Recommendation Report for Planning Permission for Works or Extension to a Dwelling

REF NO: WA/43/20/HH

LOCATION: 9 Long Mead
Walberton
BN18 0QG

PROPOSAL: Extend length of existing porch by 2 square metres, move exiting gate in line with porch and add security fence panel. Add three low panel to existing wall.

Relocated Gates plus Security Fence & 3 Small Fences

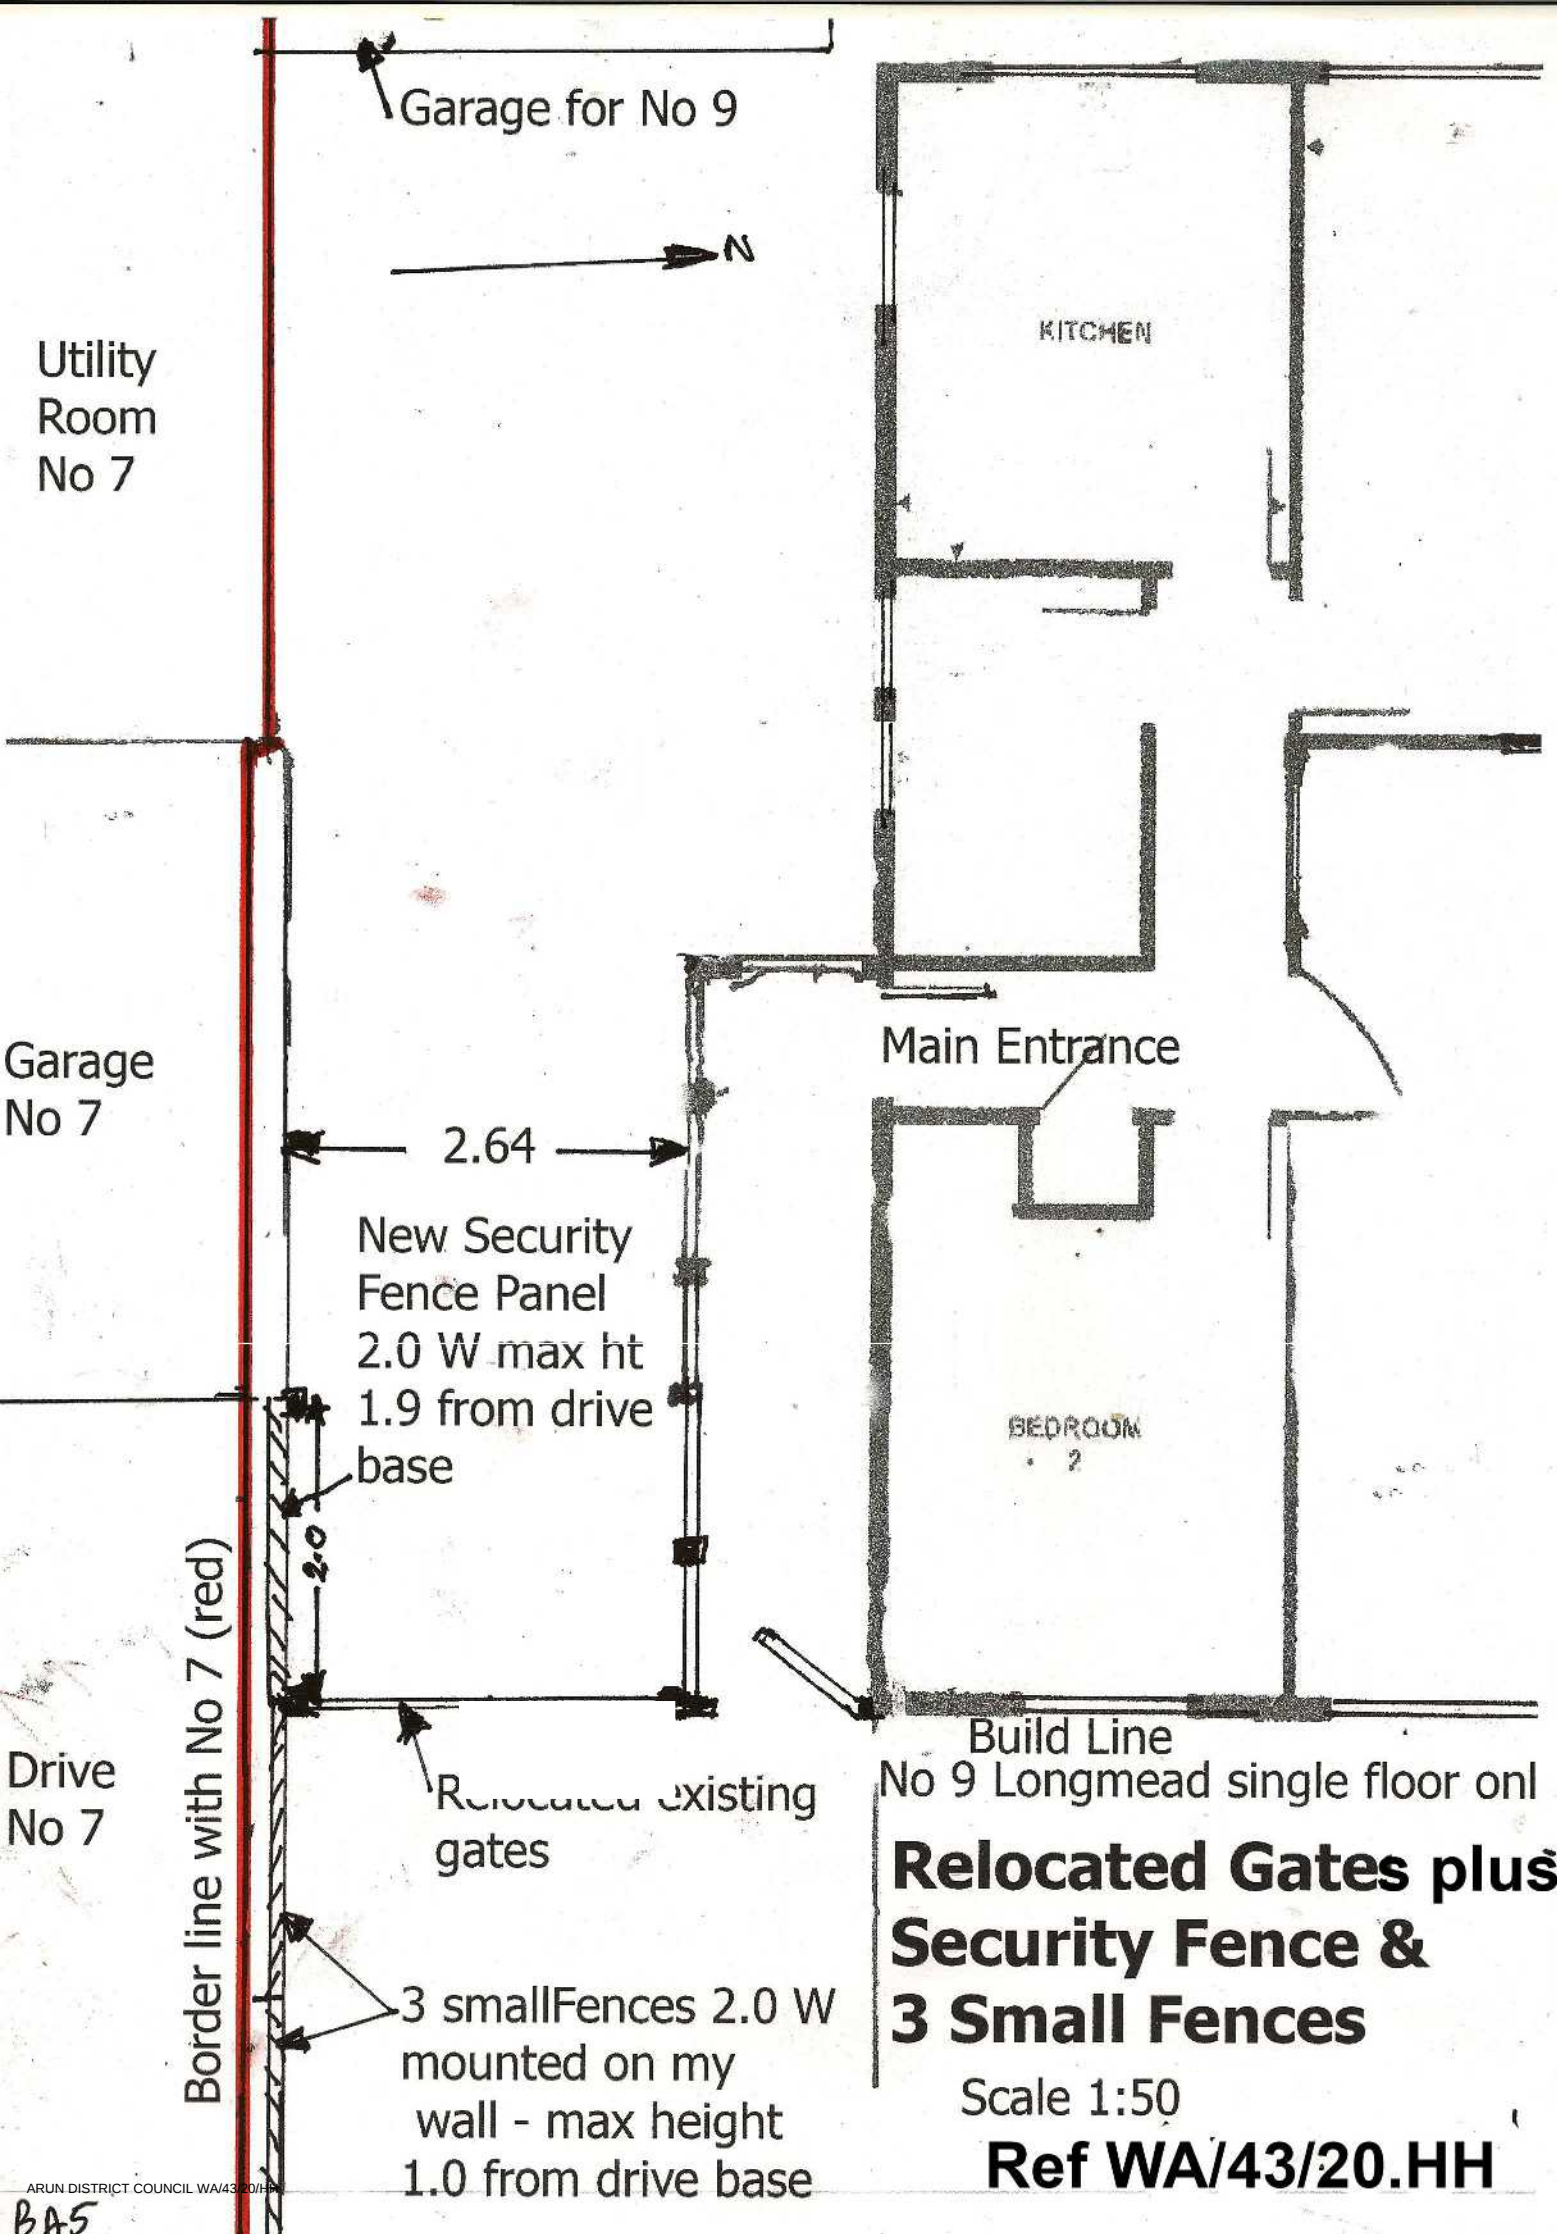
The fencing will be visible within the street scene, due to its siting to the front of the property. The fencing is approximately 1.8m high, directly abutting the neighbouring driveway. The area is predominantly host to either open plan frontages, or low boundary fencing.

Whilst the proposed fencing is not considered to be a positive feature as it encroaches upon the street scene and goes against the open plan nature of Long Mead and surrounding area, they could be erected under the permitted development rights. As a result permission as part of this application cannot be refused as doing so would mean taking permitted development rights away.
